**WEST SUSSEX COUNTY COUNCIL
INFRASTRUCTURE CONSULTATION**

SUBJECT: BR/142/10

207 Chichester Road, Bognor Regis

**Extension and COU of an existing office/storage building to residential use to
provide 3x1-bed units**

PROPOSED GROUND FLOOR PLAN

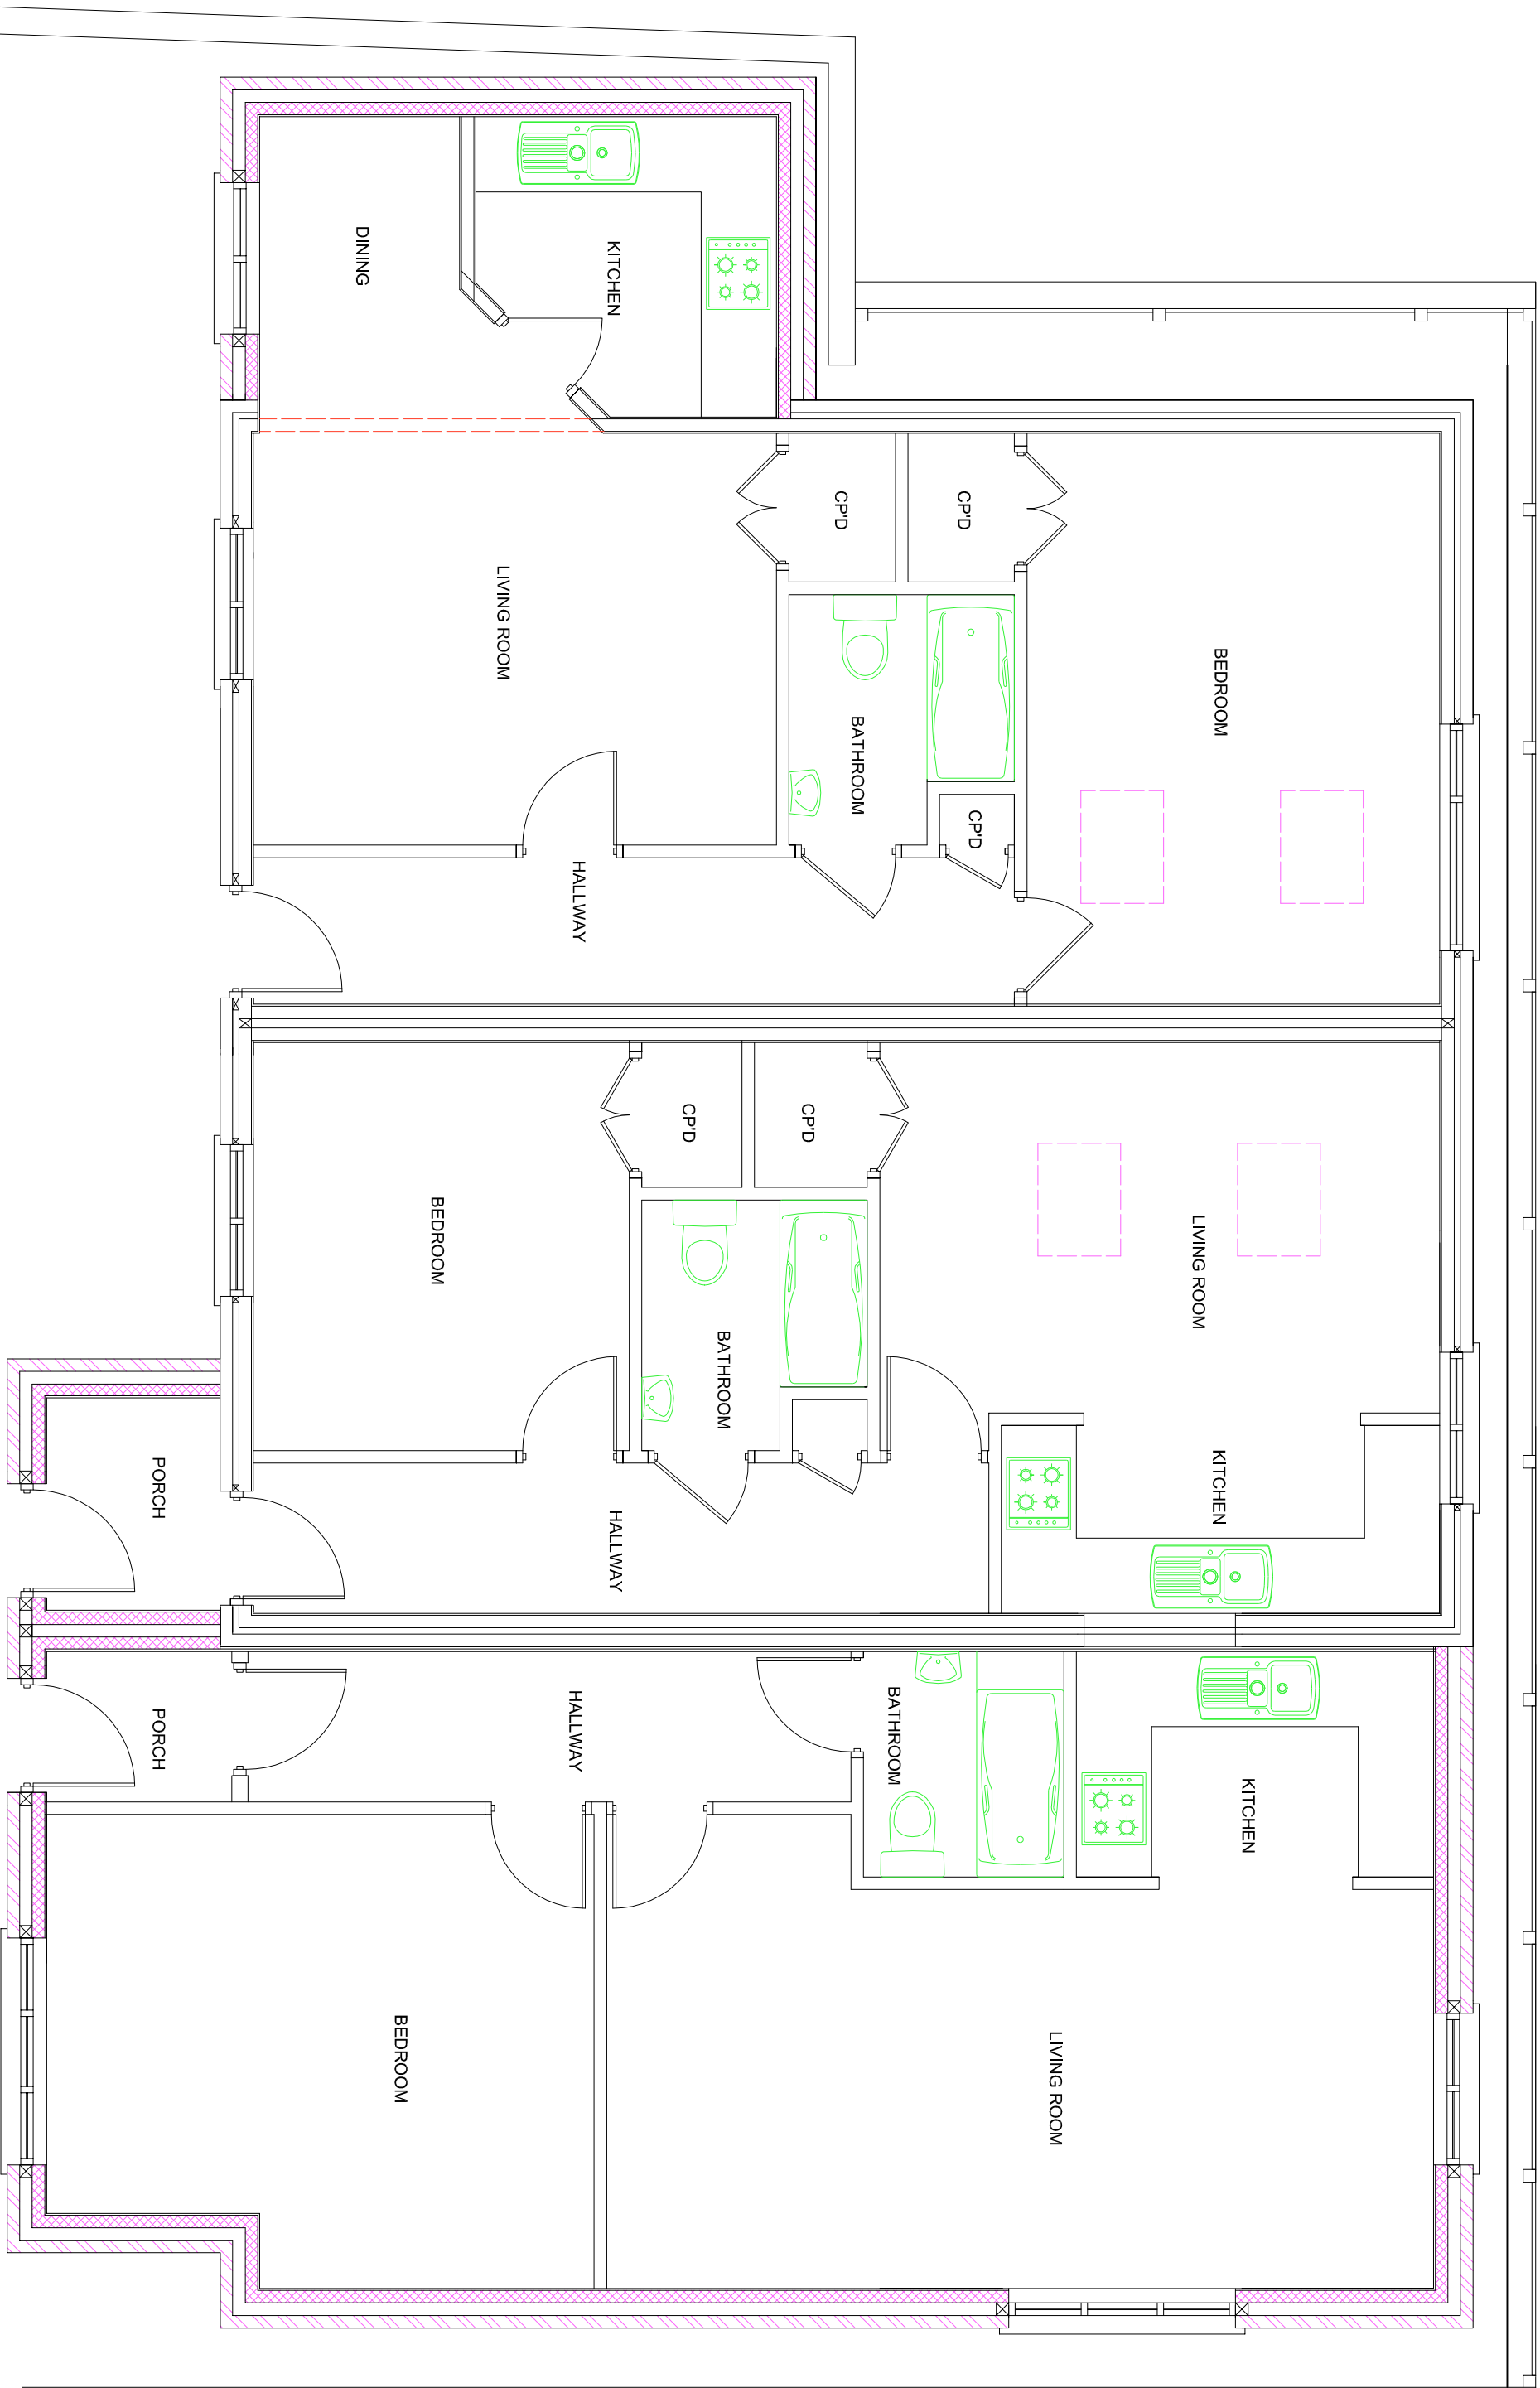
From an inspection of the plans alone, the new proposal would be anticipated to result in a net reduction in vehicle movements at the site in comparison to those approved by WSCC under BR/73/09. Parking for the new residential units is within WSCC's standards, and the alignment of these spaces allows for vehicles to turn within the site and exit in a forward gear.

The property is situated in a sustainable location and cycle parking has been included as part of the proposals.
